From: Stephanie <lingsiew@tpg.com.au>
To: "plan_comment@planning.nsw.gov.au" <plan_comment@planning.nsw.gov.au>, K...
Date: 3/12/2012 10:30 am
Subject: NWRL Environmental Impact Statement 2: An Overview SSI-5414

Attention: The Director, Infrastructure Projects,

Figure 6.12 Cherrybrook Station - Indicative vehicle and pedestrian movements

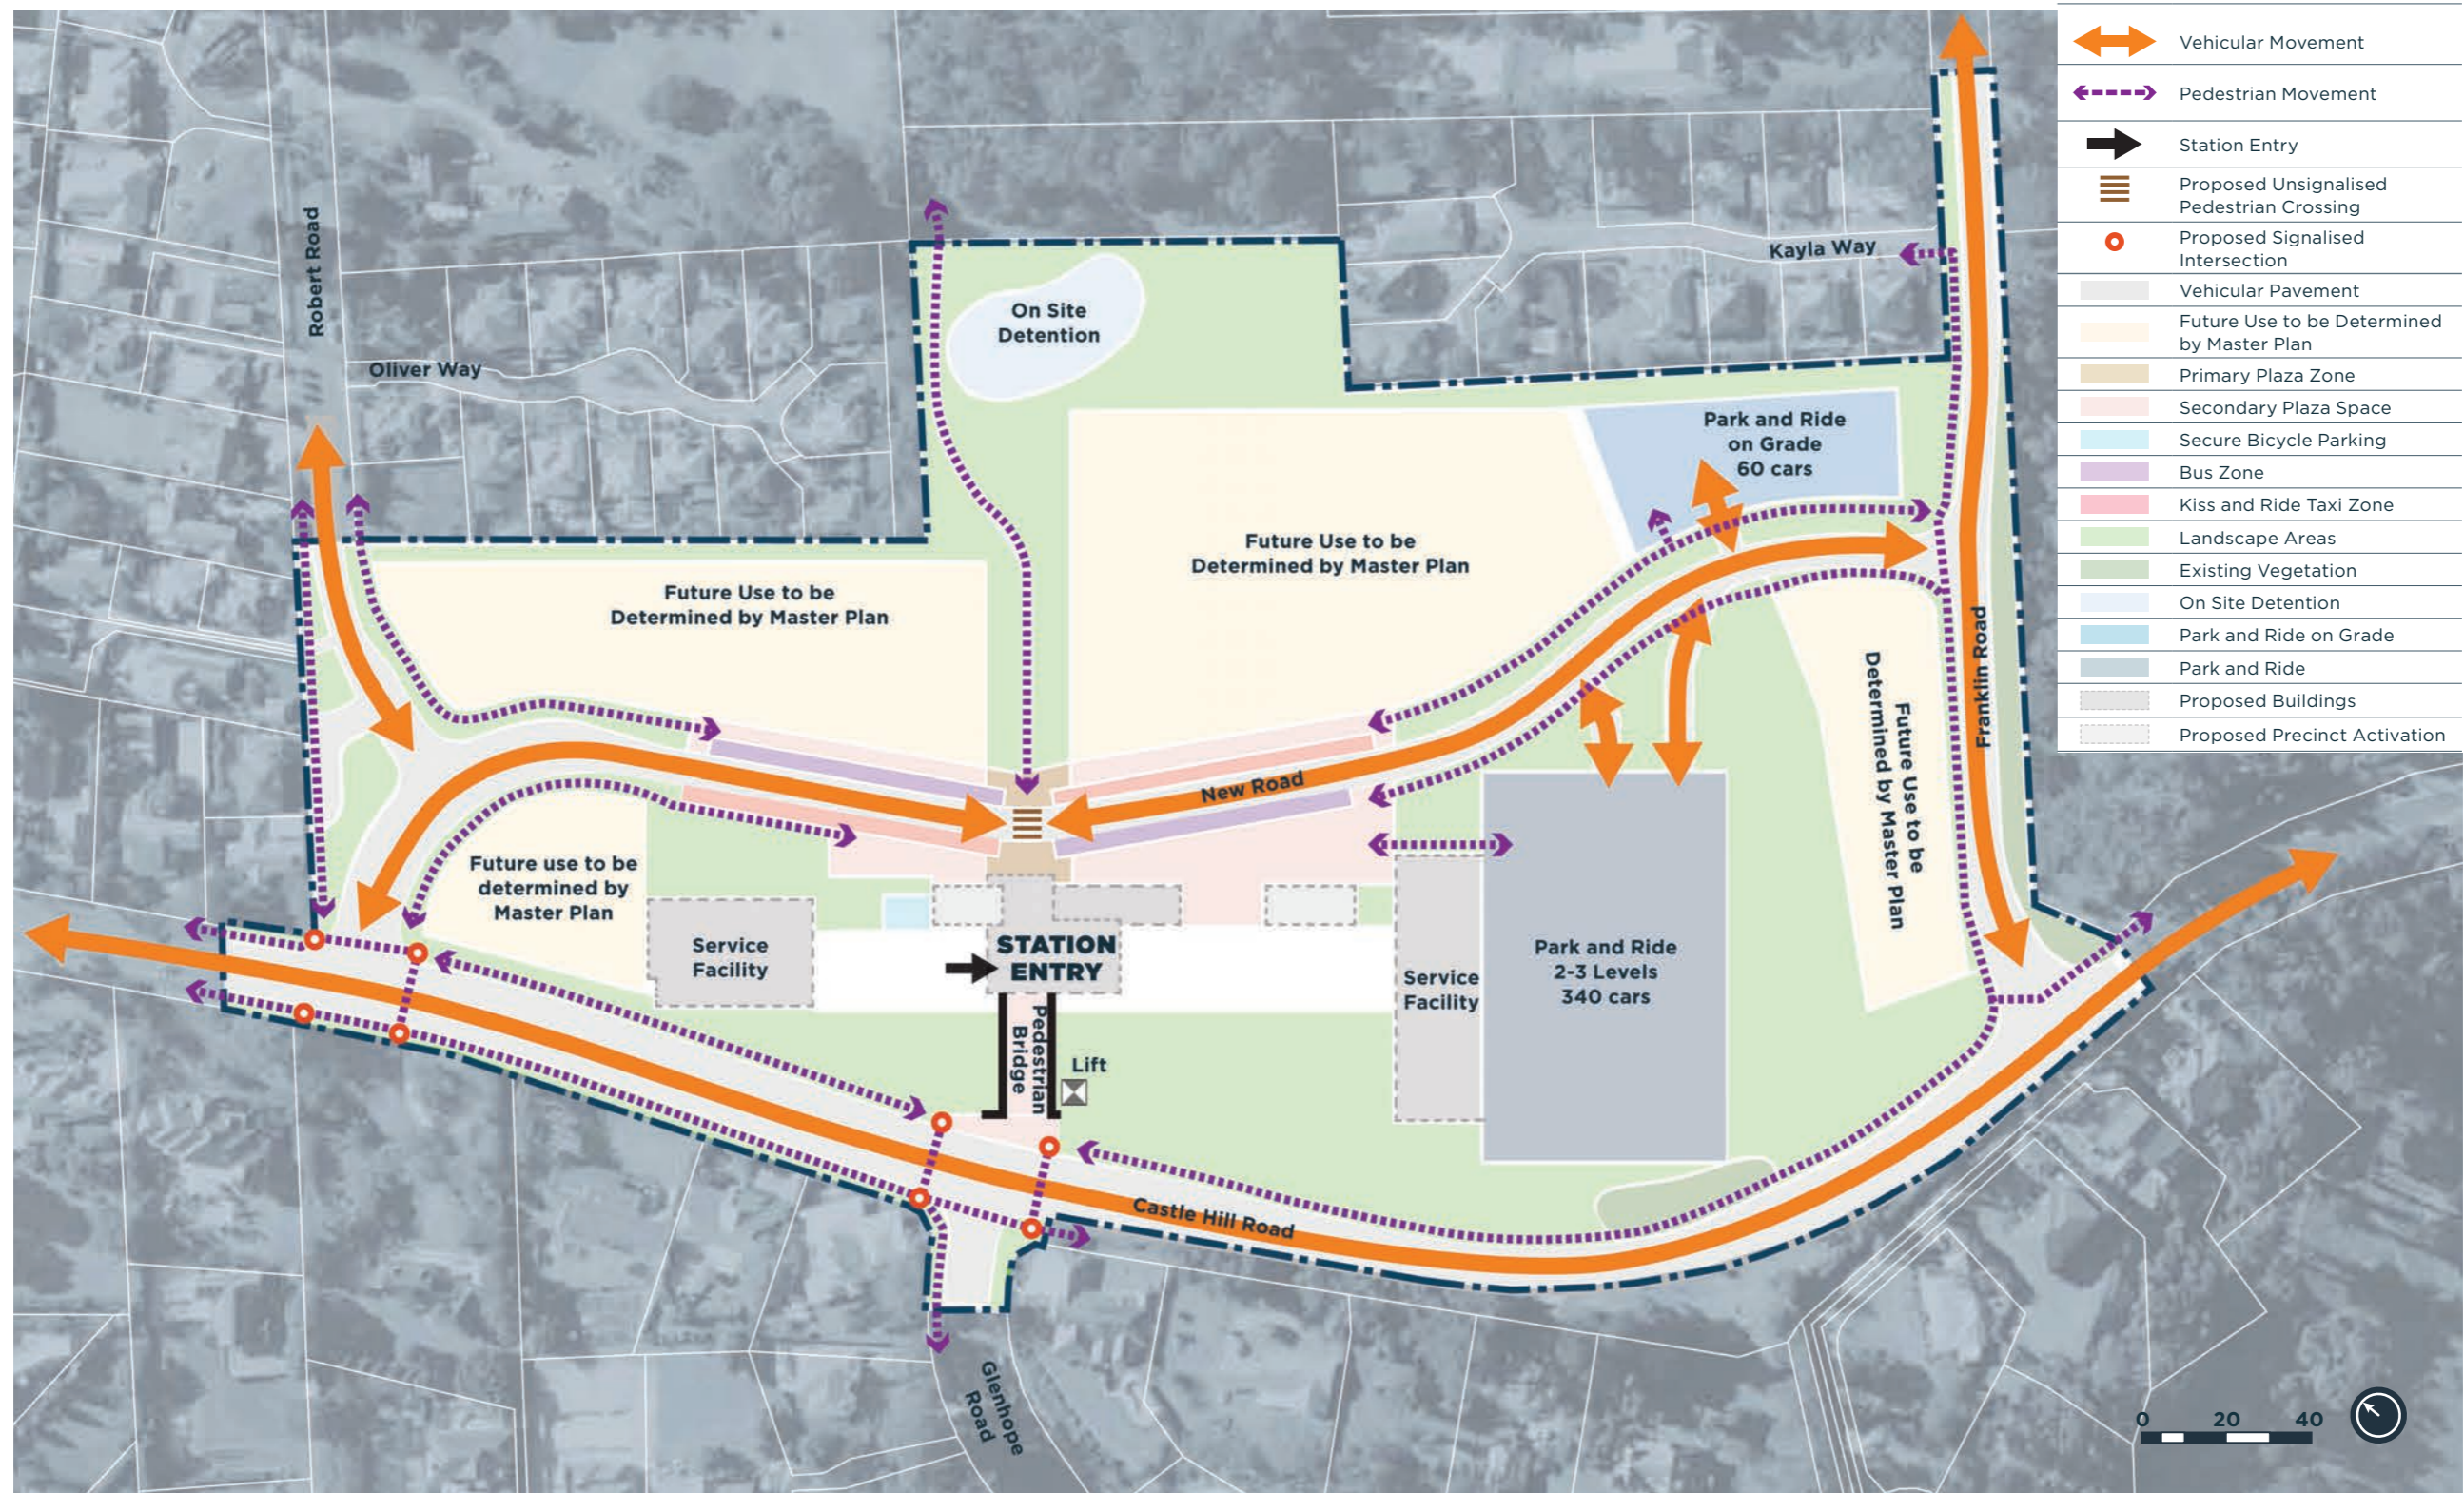
We are residents of 42 Robert Road, Cherrybrook NSW. I am writing to express my opposition to use Robert Road as the bus route to access the new Cherrybrook station and the prohibition of parking alongside Robert Road. Robert road is a narrow and quiet street which is not designed to accommodate heavy traffic flow and buses going through. Due to the narrowness of Robert Road, to let buses turn right from John Road to Robert Road then through to the new Cherrybrook station is a nonsense and ridiculous proposal as it will not only cause jamming traffic in the T-junction of Robert Road and John Road, it is inevitable causing danger to the passers-by residents and vehicles. The prohibition of parking cars alongside Robert Road is abusing the rights of the local residents. As residents, we rely on on-street parking to accommodate our cars because most of us are living in 500 to 600 meters blocks with 1 to 2 garages sharing by parents and 1 to 2 grown up children who are drivers with their own cars. We are also embarrassed by asking our friends, especially when they are aged and unable to walk well to park one or two streets next blocks when coming for visiting us. I think your Authority should give an explanation why residents of Robert Road have to be deprived of their rights from on-street parking as all other residents all around the State. I am not convinced that we, as the local residents, should sacrifice our rights to make way for the users of the new station as we are the one we actually living in here day by day. Our well beings should come before those drop-by users!

I suggest your authority to use County Drive as the bus route and main traffic feeder to the new station. Buses should go to the station from left lane of County Drive to Castle Hills Road then turn left to the Cherrybrook station. County Drive is the best choice among Franklin Road and Robert Road, someone with normal eyesight and senses should have no problem in realizing that County Drive is wide enough to accommodate heavy traffic and buses going through. And that, your authority has also owed an explanation to the Robert Road residents what is the rationale behind using Robert Road instead of County Drive? Why choosing Robert Road instead of County Drive?

To reiterate my view, I am strongly opposed to use Robert Road as bus route to the new station and the prohibition of parking alongside of Robert Road. County Drive is no doubt the better choice for going buses!
